## PLANNING CONSULTATION RESPONSE

<b>Application No</b>	2025/0920
<b>Proposal</b>	Demolition of existing side single story extension and garage; erection of two storey side; rear single storey extensions; front entrance porch and detached double garage with alterations to driveway and parking arrangements
<b>Address</b>	St Johns Close, 379 Carlton Road, Carlton, Barnsley, S71 3JB
<b>Date of Consultation Reply</b>	21/11/2025
<b>Consultee</b>	Highways Development Control

BLOCK PLAN AS PROPOSED  
SCALE 1:500

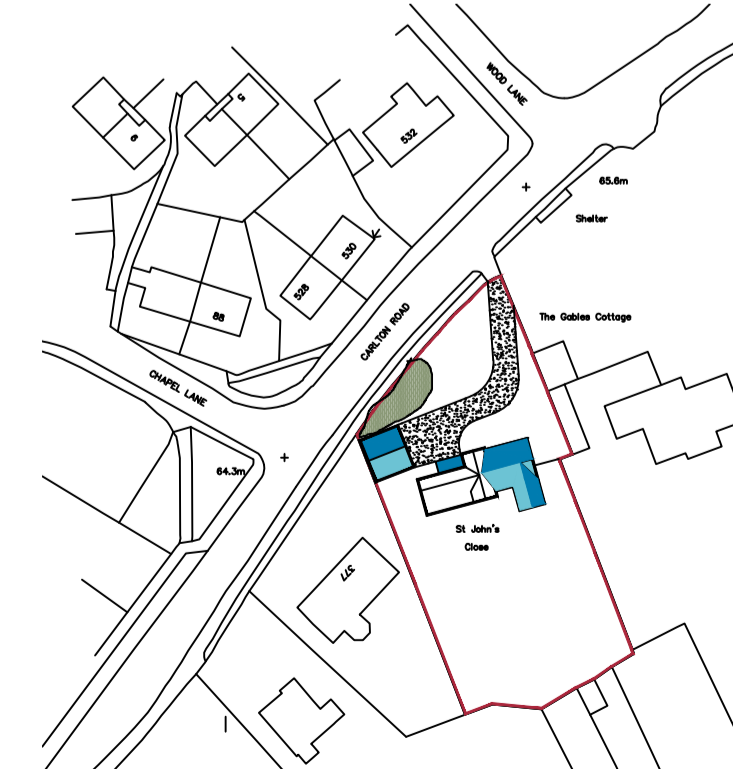
The proposed extension and erection of a detached garage gives no cause for concern. The site has ample parking and room for vehicles to turn within the site curtilage and as such, there are no objections from a highways point of view. The applicant will however, need to ensure that the driveway is surfaced in a bound material for the first 5m into the site to prevent the migration of loose material on to the public highway. I would also take this opportunity to ensure that appropriate drainage measures are installed to prevent the discharge of water on to the highway and I have included a condition of that nature below.

Before the development is brought into use, that part of the site to be used by vehicles shall be surfaced in a bound, solid material for the first 5m and adequate

measures shall be so designed into the access to avoid the discharge of surface water from the site on to the highway.
